**LETTER OF INTENT  
9495 PEACEFUL VALLEY RD. – MINOR AMENDMENT to DEVELOPMENT  
PLAN**

John P. Nelson Associates  
1626 E. Pikes Peak Ave.  
Colorado Springs, CO 80909  
October 9, 2019

# Letter of Intent\_v1.pdf Markup Summary

SITE /LANDSCAPE PLAN

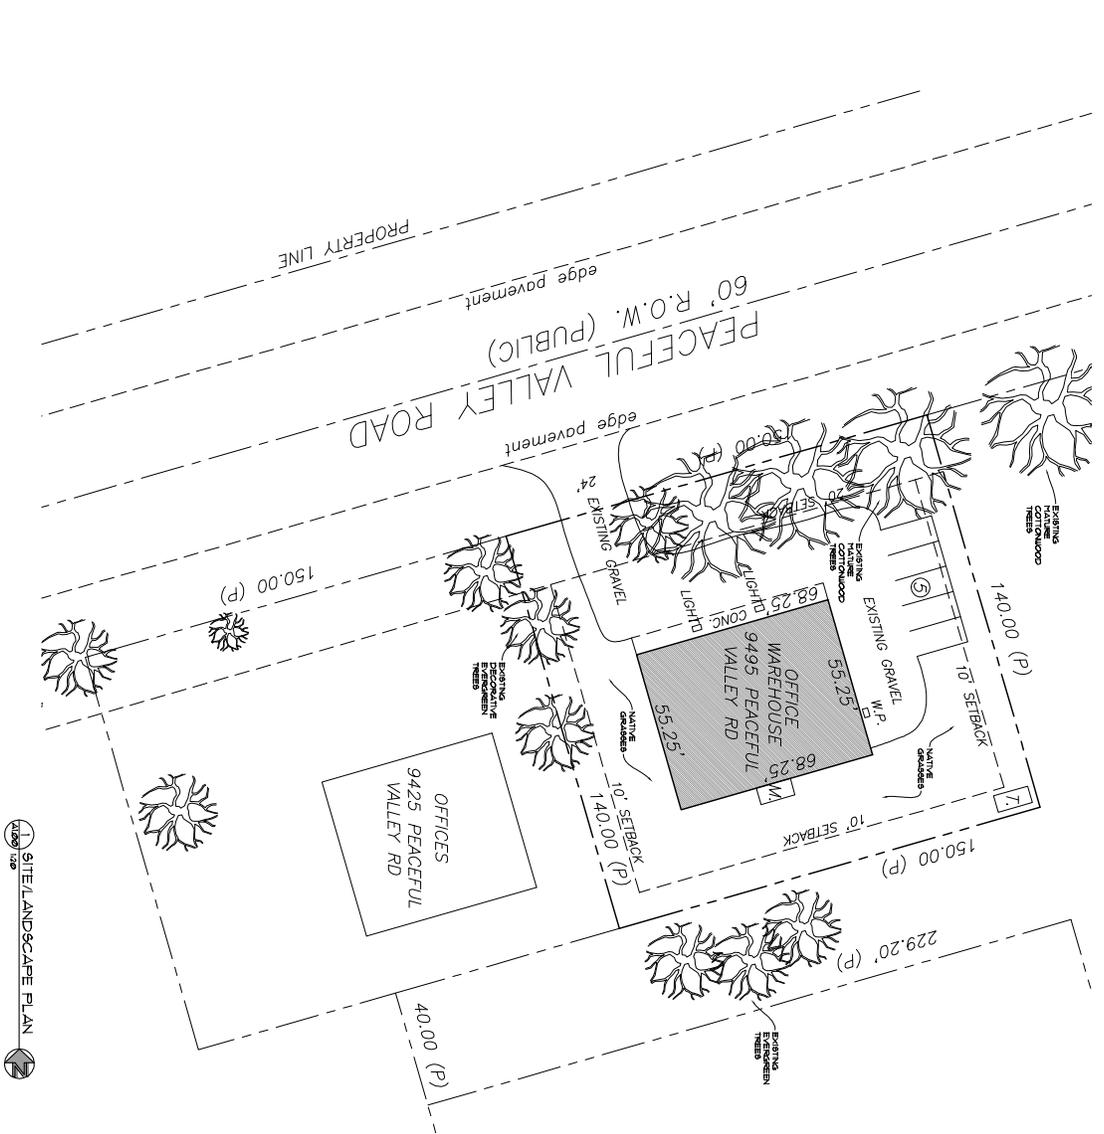
Not shown on  
landscaping

Existing landscaping is inadequate. Site will need to meet the requirements of the  
landscaping code section 6.2.2 of the LDC.

Site plan was uploaded instead of floorplans

Not shown on landscaping

Existing landscaping is inadequate. Site will need to meet the requirements of the landscaping code section 6.2.2 of the LDC.
